File No: NTH21/00090/02
Your Ref: SSD-16848913

**RE: Review of Environmental Impact Statement (SSD-16848913)
Murwillumbah Education Campus - 86 Riverview Street, Murwillumbah**

I refer to your referral of 26 April 2022 requesting comment from Transport for NSW (TfNSW) in relation to the abovementioned State Significant Development.

SITE LAYOUT - STAGE 1B

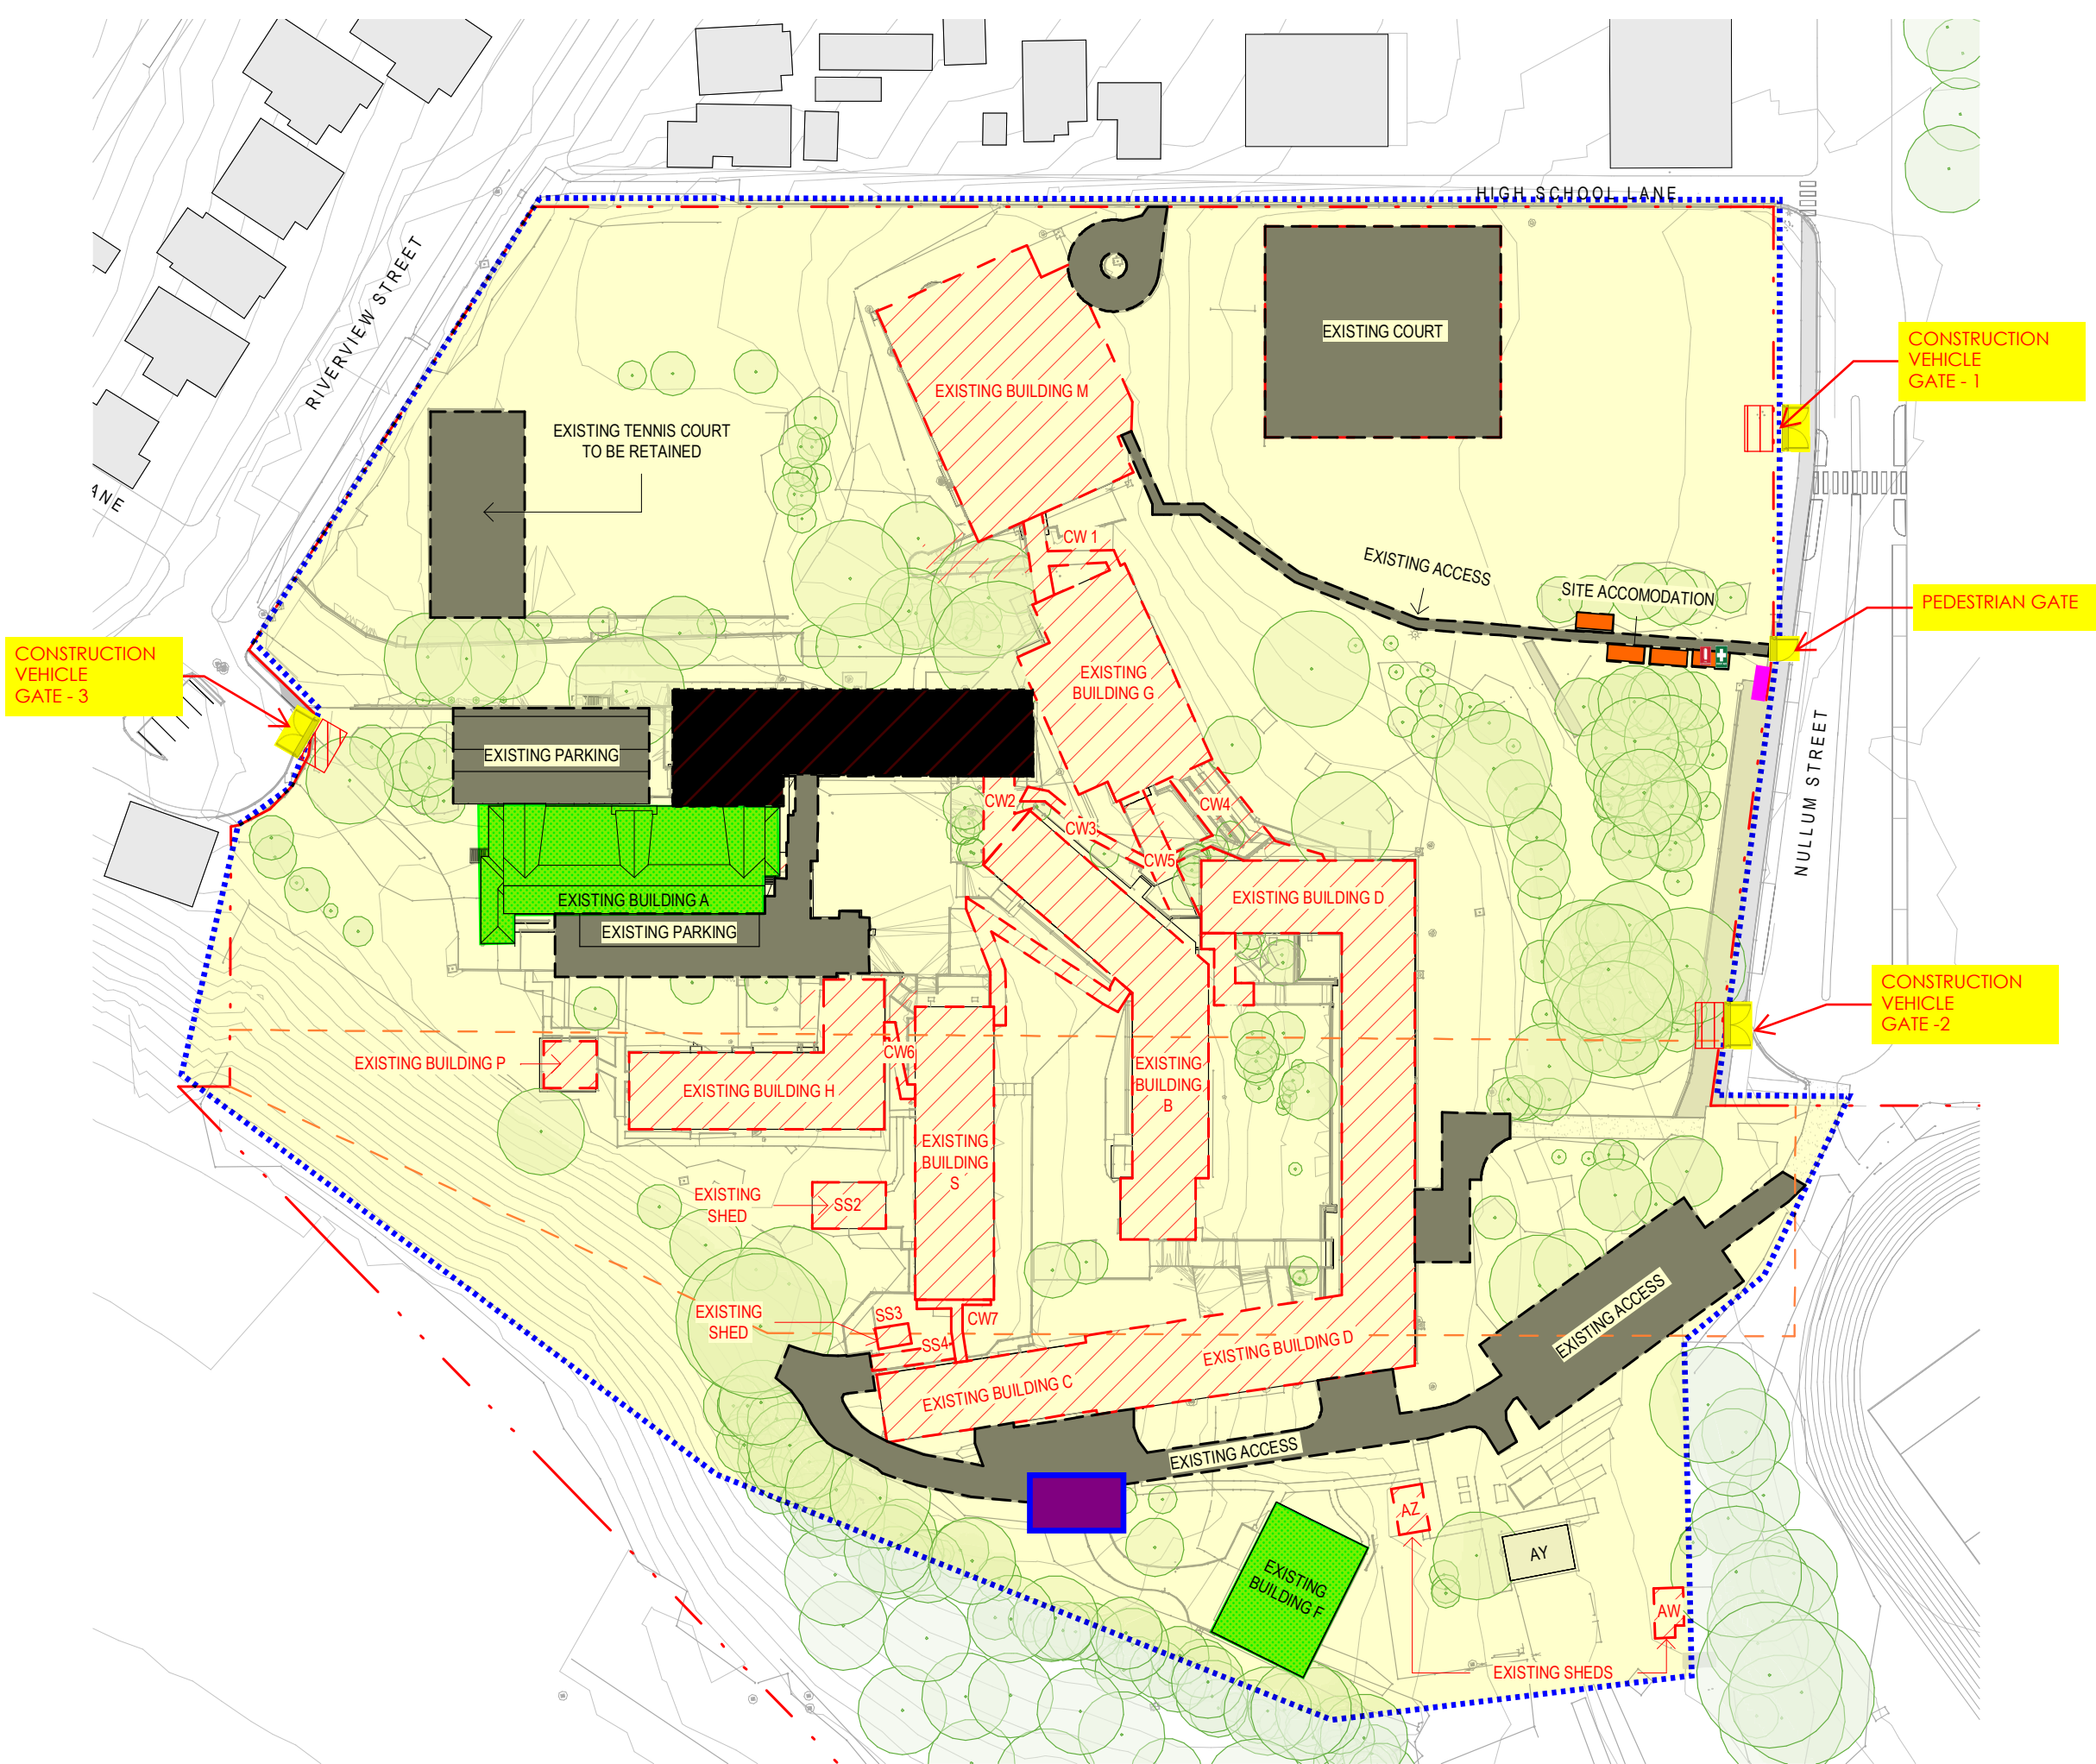
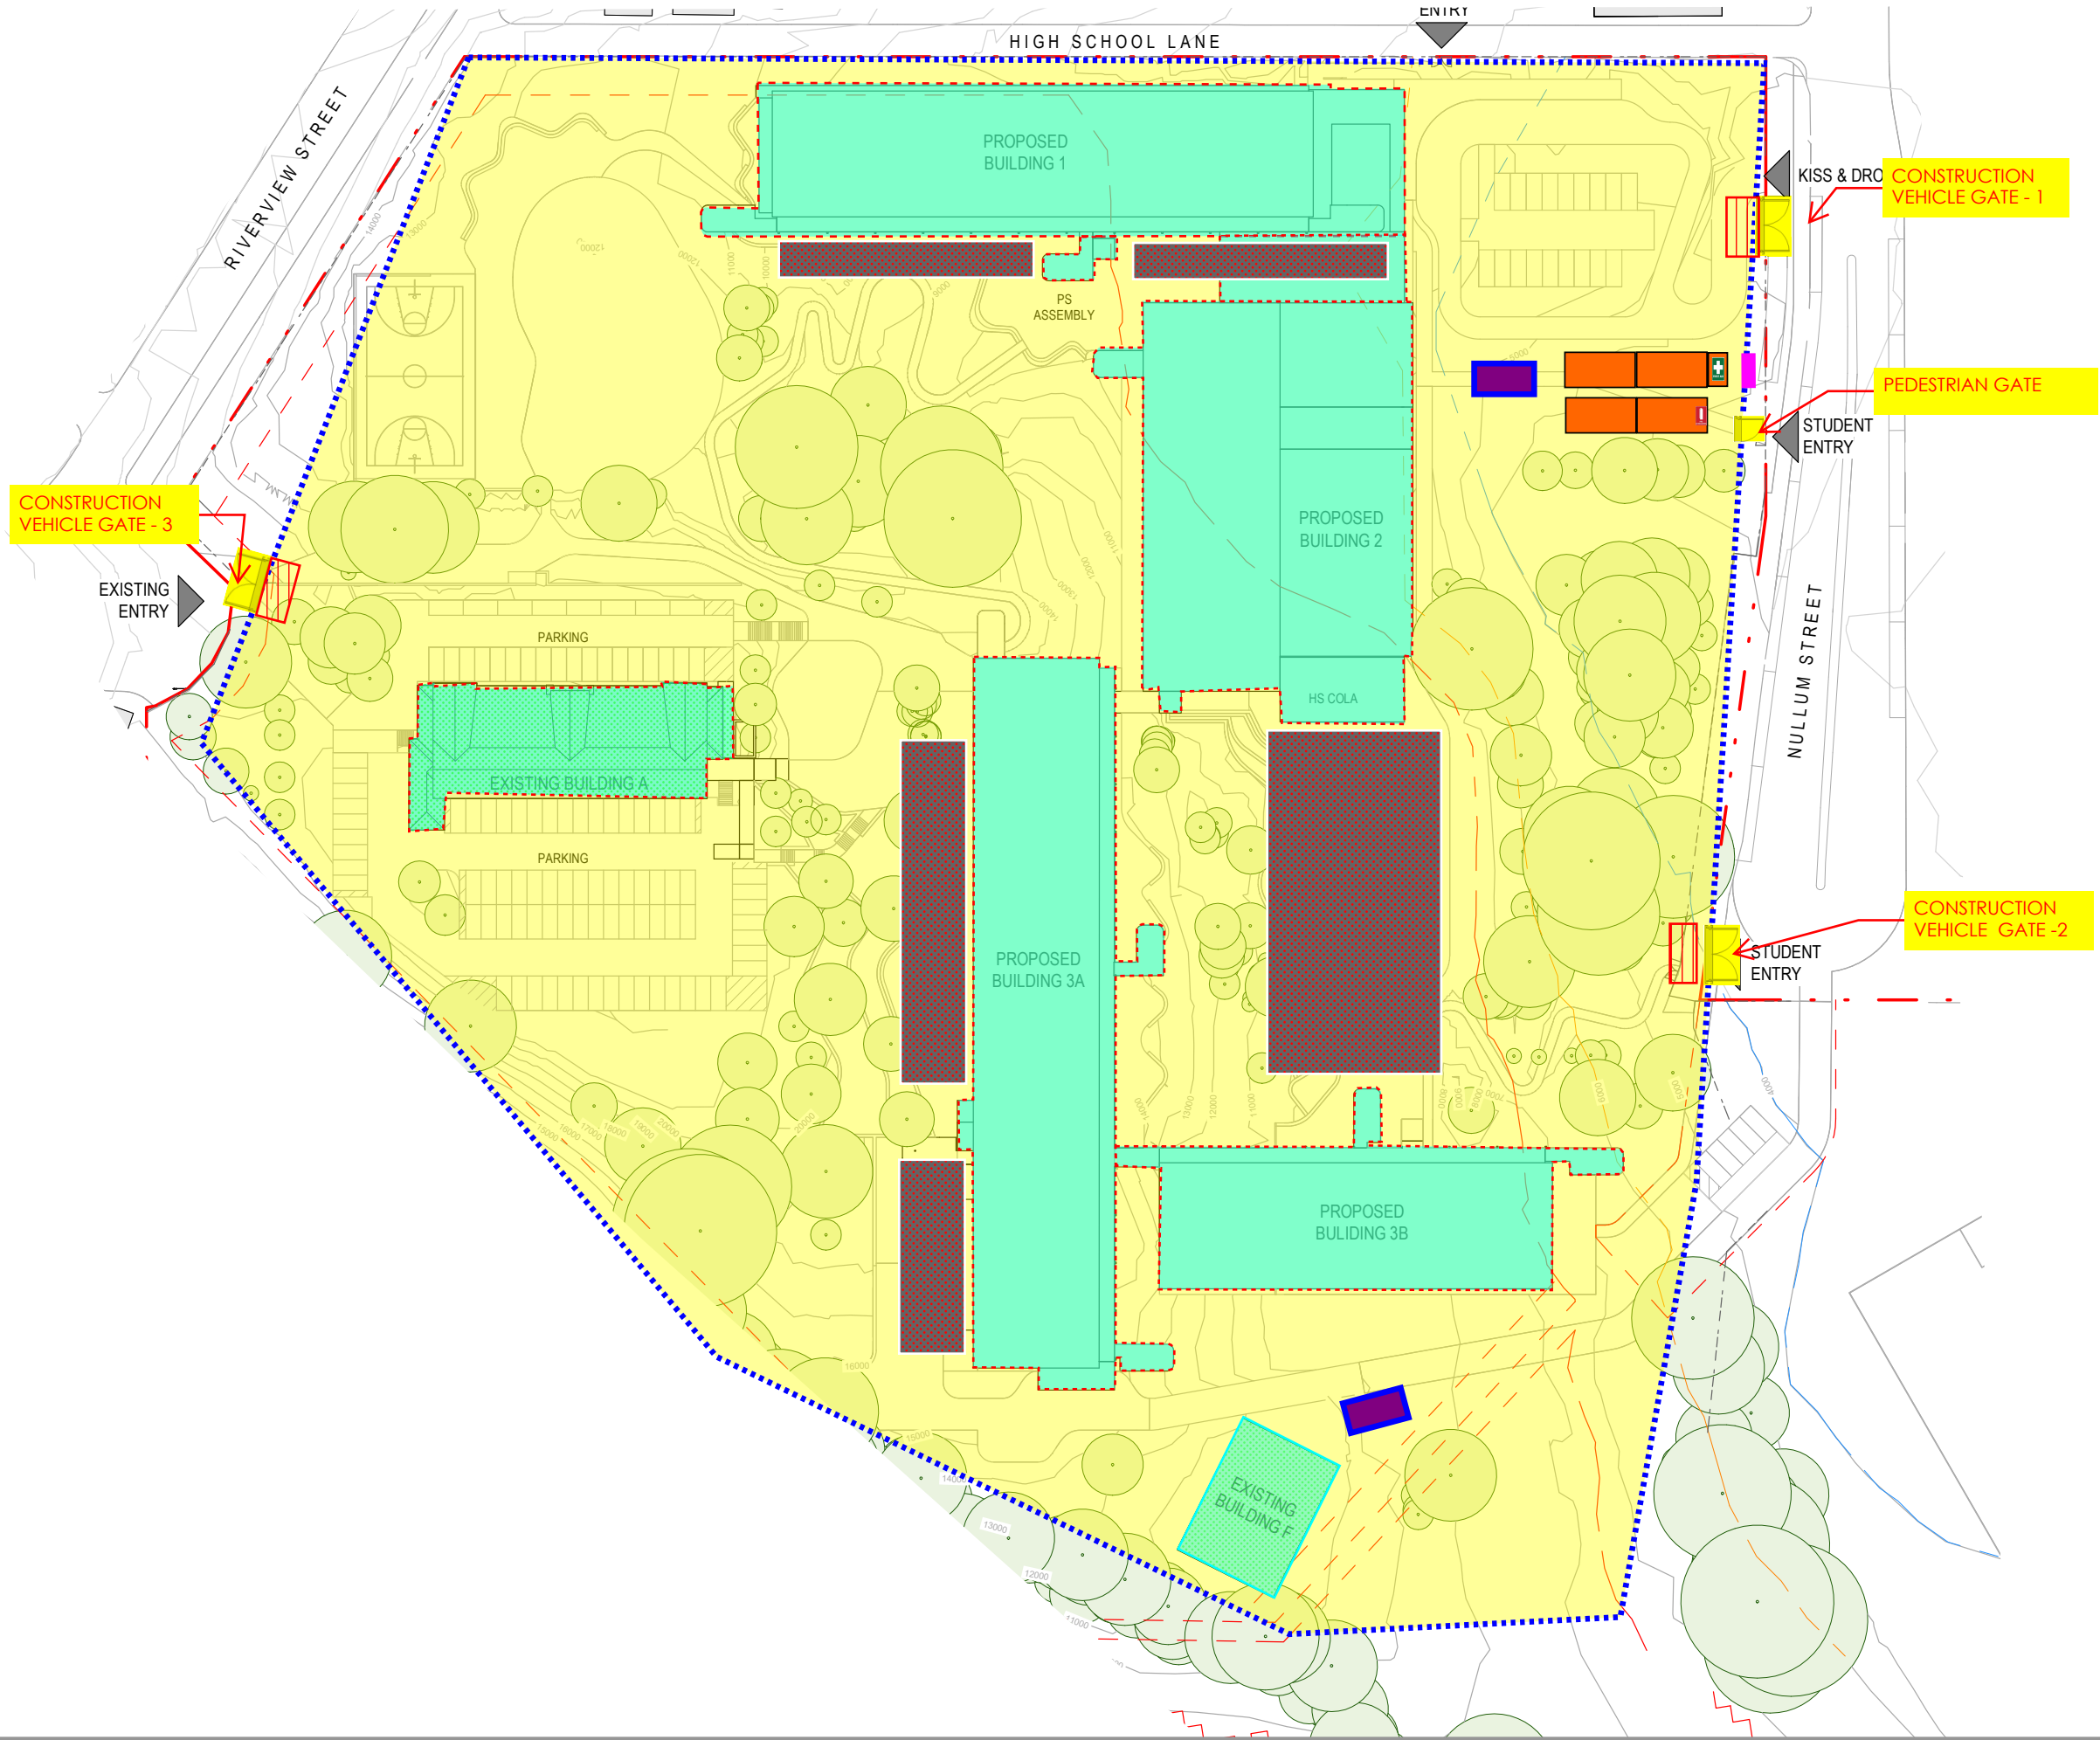
- The Construction Traffic Management Plan (CTMP) identifies three (3) construction vehicle access gates. Gate 3 requires the implementation of a Traffic Guidance Scheme (TGS) reducing Riverview Street to a single carriageway, with contra-flow arrangements proposed to manage traffic during phases one and two of construction. The suitability of this arrangement should be further discussed with Council to confirm that it is supported and can be implemented prior to commencement of construction.

Figure 2.2 shows the public and school bus routes for the existing four schools. It is noted that not all school bus providers currently have documented bus routes and timetables.

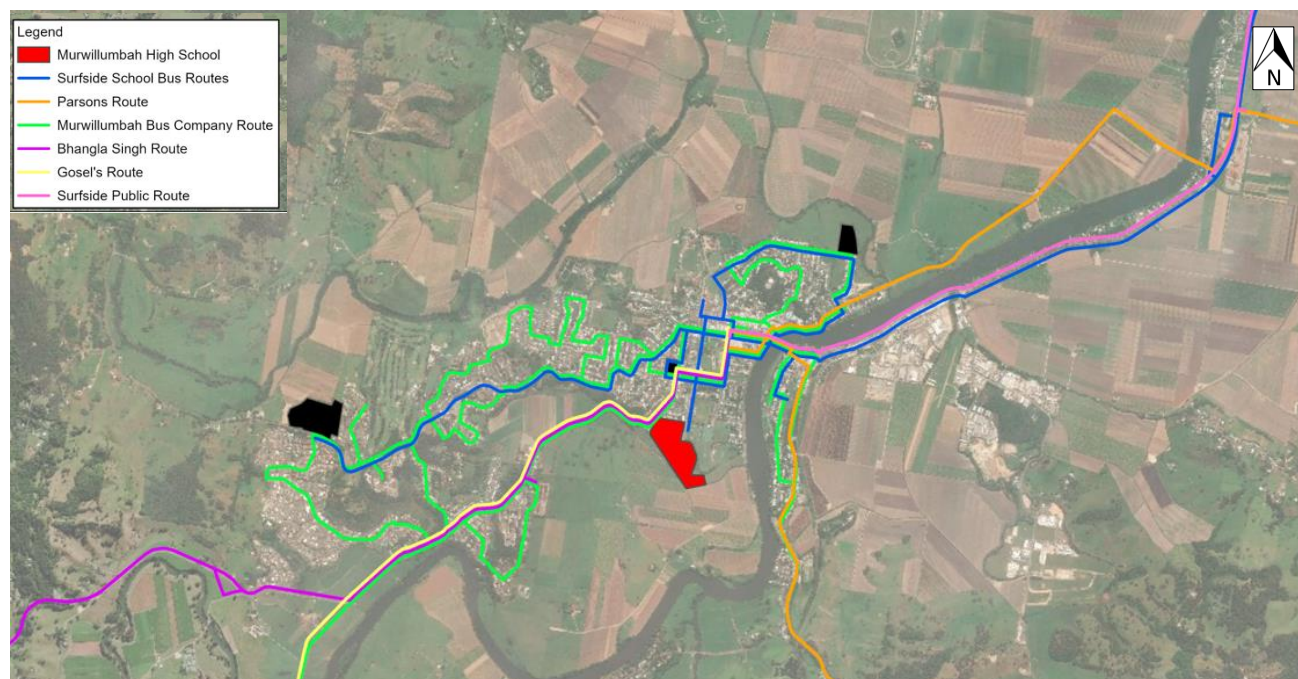
TfNSW has identified the need for additional work to identify changes required to school bus services during the construction and operational phases of the project. This work needs to consider the temporary relocation of students during construction and the relocation of new students to the site prior to occupation. This work needs to be carried out prior to the commencement of construction. It is noted that the Proponent has established a working group with TfNSW, Council and relevant bus service providers to enable this work to progress. It is recommended that the EIS clearly identify this process and any proposed mitigation measures, including any new facilities require to support any change in school bus routes.
